**STATEMENT OF ENVIRONMENTAL EFFECTS: SECTION 75W APPLICATION TO MAJOR
PROJECT MP NO.08_0257 STAGE 1 (BUILDINGS 4 & 5) – 61 MOBBS LANE, EPPING**

Pursuant to Section 75W (1) (a) of the Environmental Planning and Assessment Act 1979, a 'modification of approval' is sought to vary Condition No. A2 pertaining to Major Project MP No. 08_0257 Stage 1 (Buildings 4 & 5) as approved on the 15 September 2010. The modification is to amend architectural plans to accommodate minor design changes to the approved architectural plans arising from design and construction compliance.

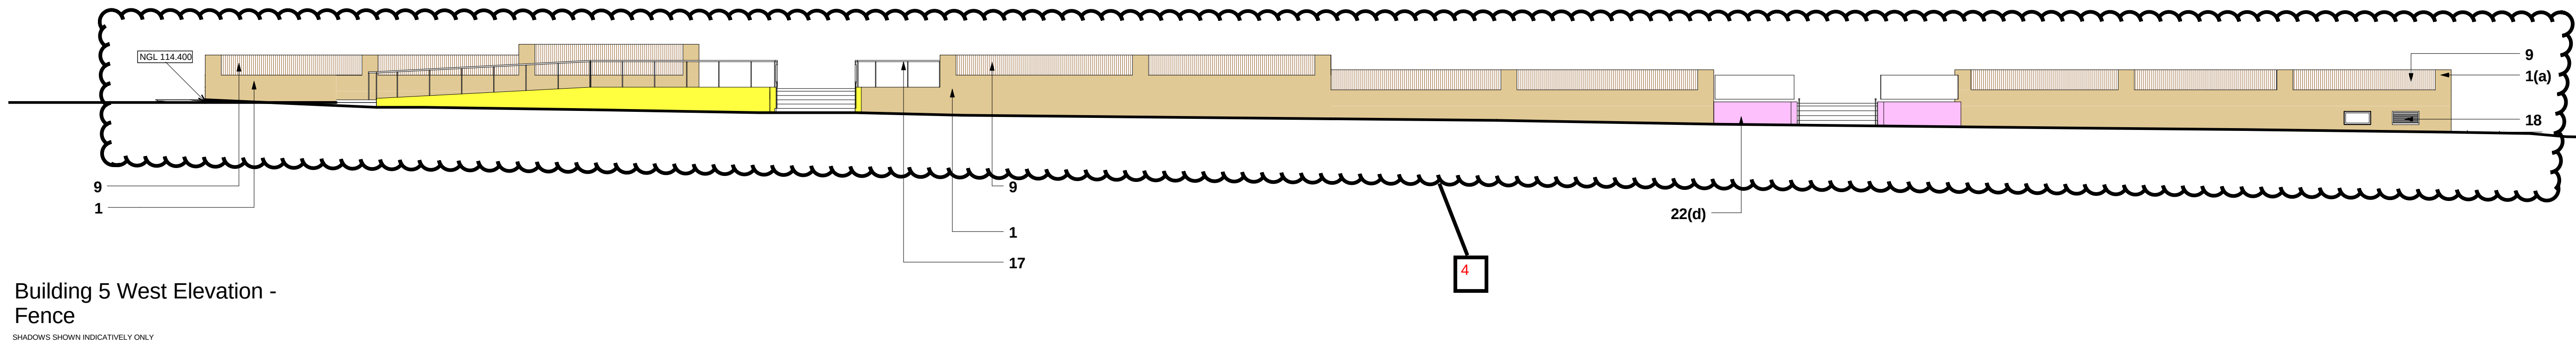
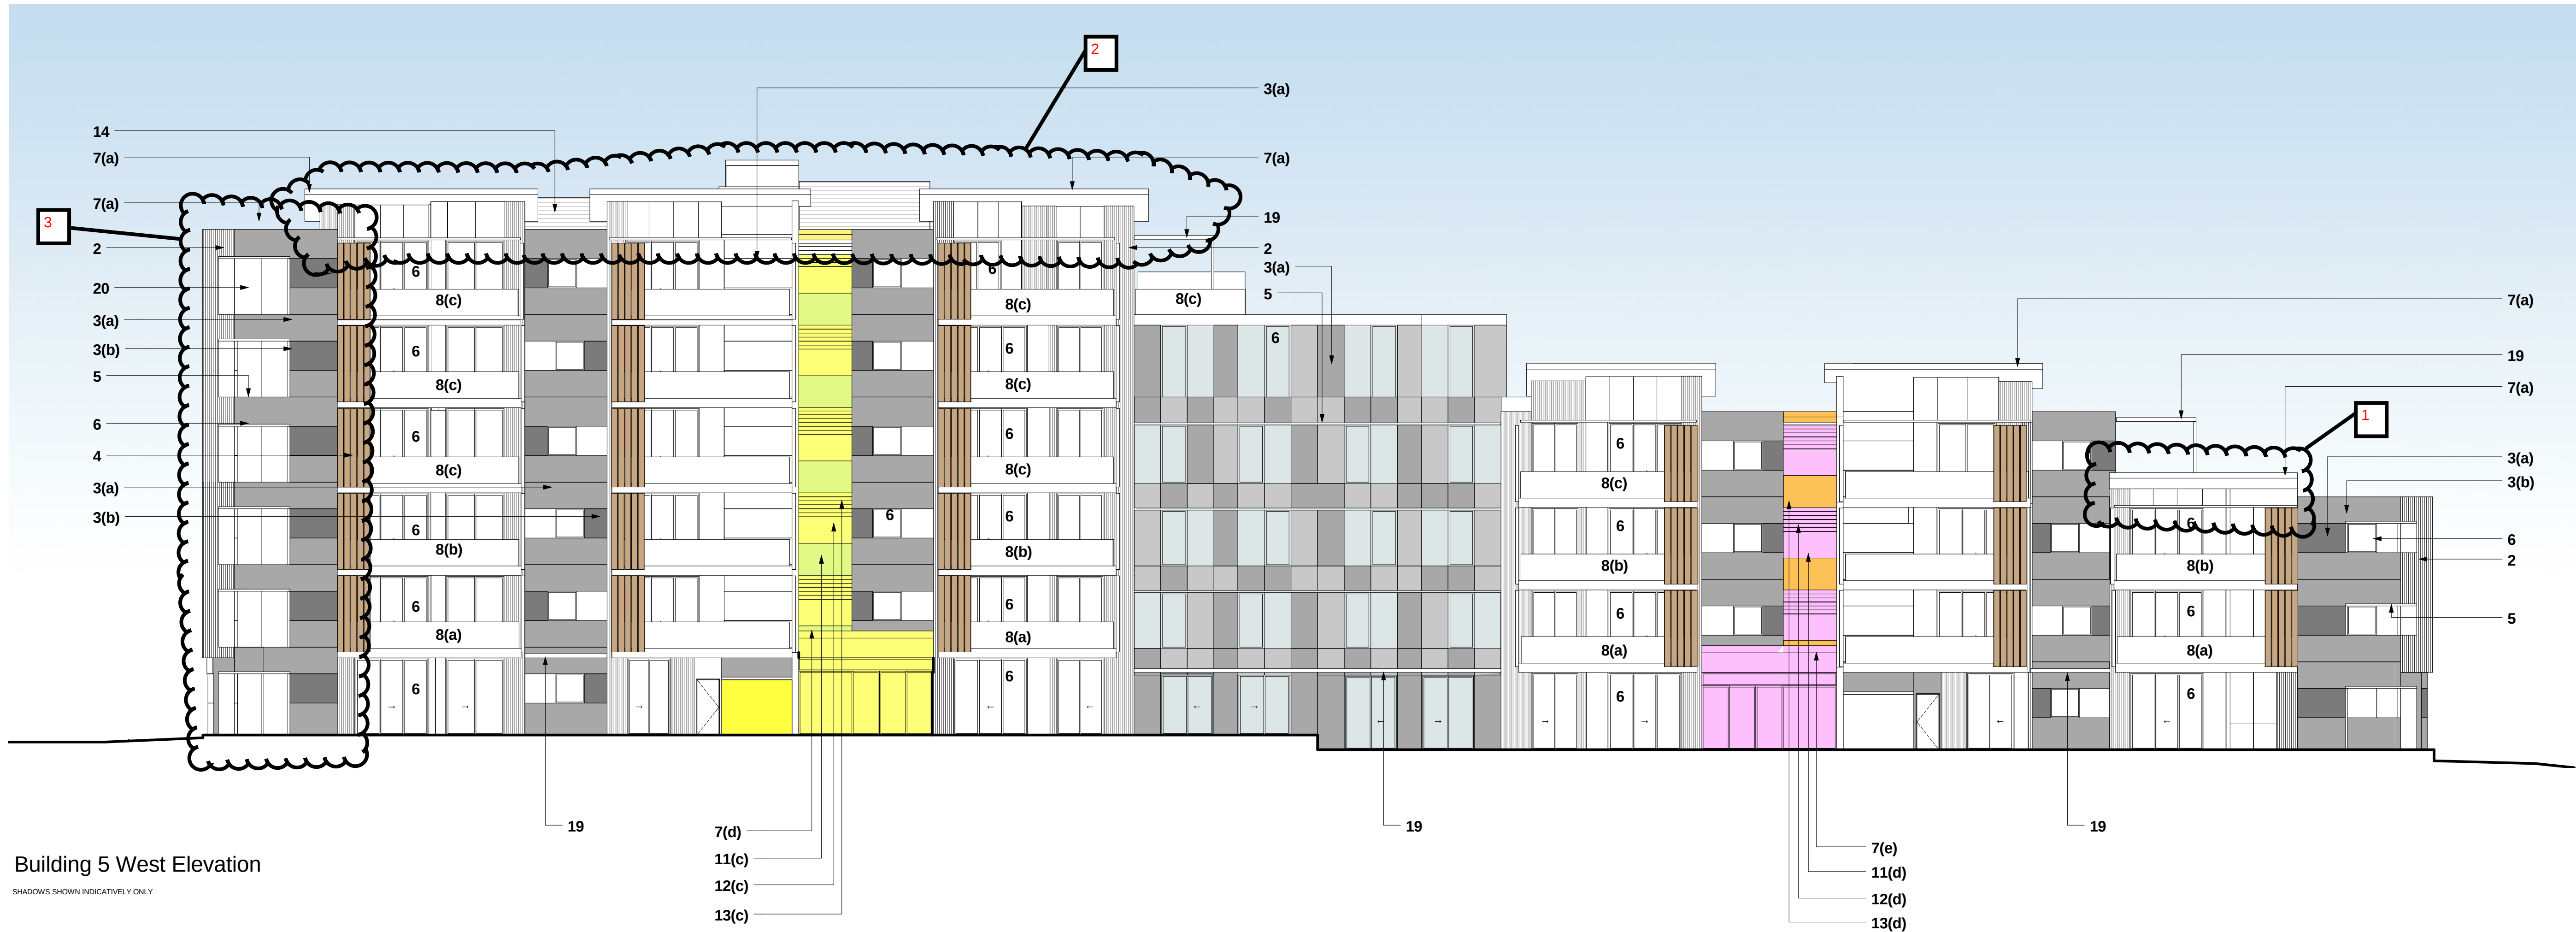
1. Change to parapet
2. Roof reconfigured
3. Size of window and awning
4. Amended fence and ground floor details
5. Amended colour legend

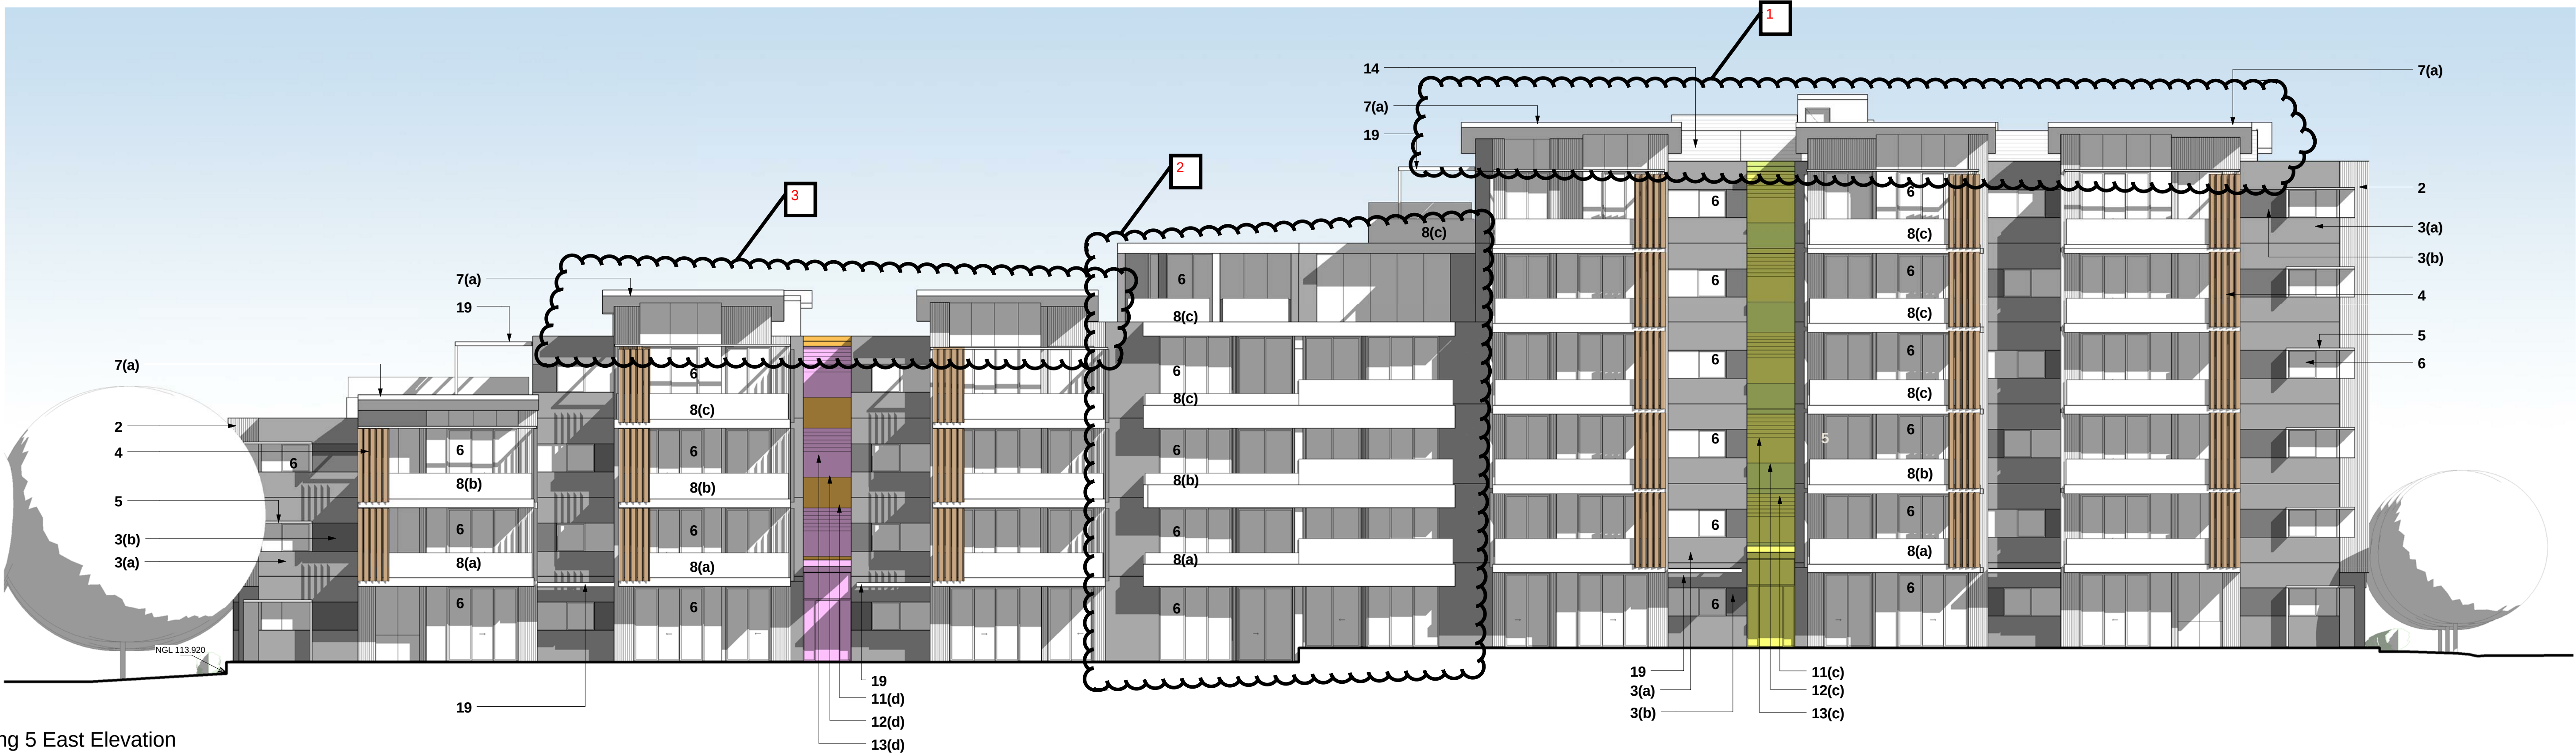
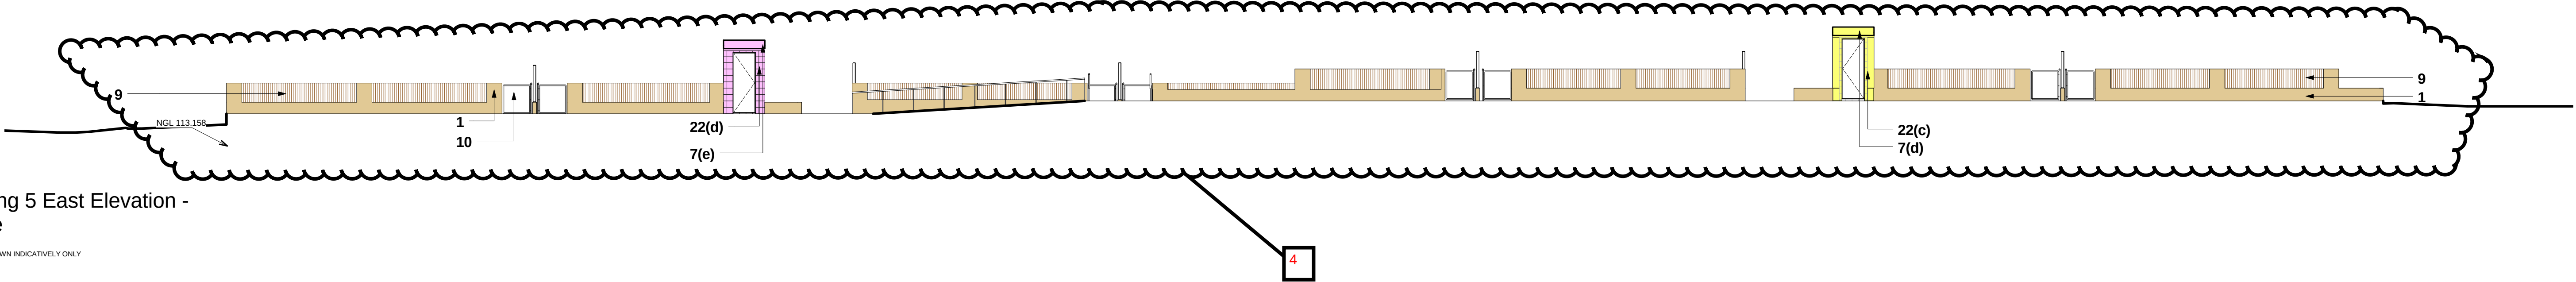
1. Roof configuration
2. Glazing precast panels and balustrade reconfigured
3. Roof reconfiguration
4. Amended fence and ground floor details
5. Amended colour legend
